HIGHWAYS REPRESENTATION

OBJECTION

Planning Reference:	23/01979/FUL
Location:	Corinthian Court, Cross Street, Shanklin, PO37 6BU
Proposal:	Proposed ramp and retention of white cladding to entrance porch.
Road Status:	Unclassified
Date of Site Visit:	06.12.2023
Date of Report:	07.12.2023
Planning Case Officer:	Victoria Taylor

Proposed Block and Location Plans

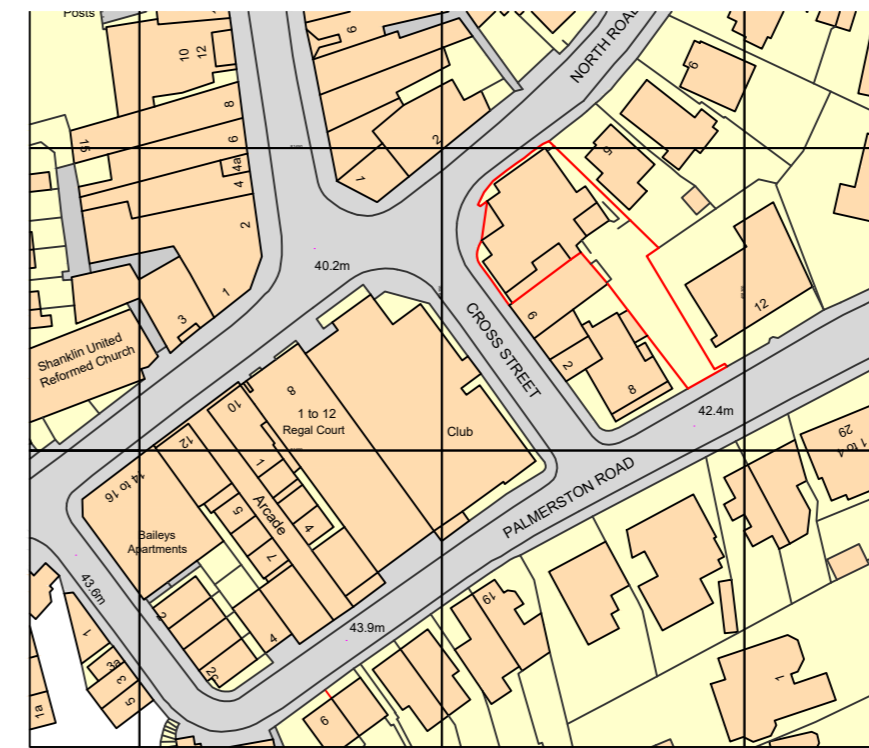
An extract from the 'Proposed Block and Locations Plan' (plan no. 020-22.5 rev 1.6) submitted in support of this planning application is shown below:

An extract of the proposed layout plan is shown below on which has been highlighted in orange the area of land where the proposed development **encroaches onto the publicly maintainable highway and outside the red line extent of this planning application**:

In conclusion, in the opinion of this Office, the public highway would continue to operate in a satisfactory manner and the area shown below could be stopped up without impacting on the public’s right to pass and re-pass along this way.

The information accompanying this application is inadequate and deficient in detail in respect to the land within the control of the applicant so that the Local Planning Authority is unable to consider fully the effects of the proposal on Cross Street and in the absence of further details, it is considered the proposal if permitted may cause an obstruction within the public highway thus constituting a hazard to highway users contrary to Policy DM2 (Design Quality for New Development) of the Isle of Wight Core Strategy.
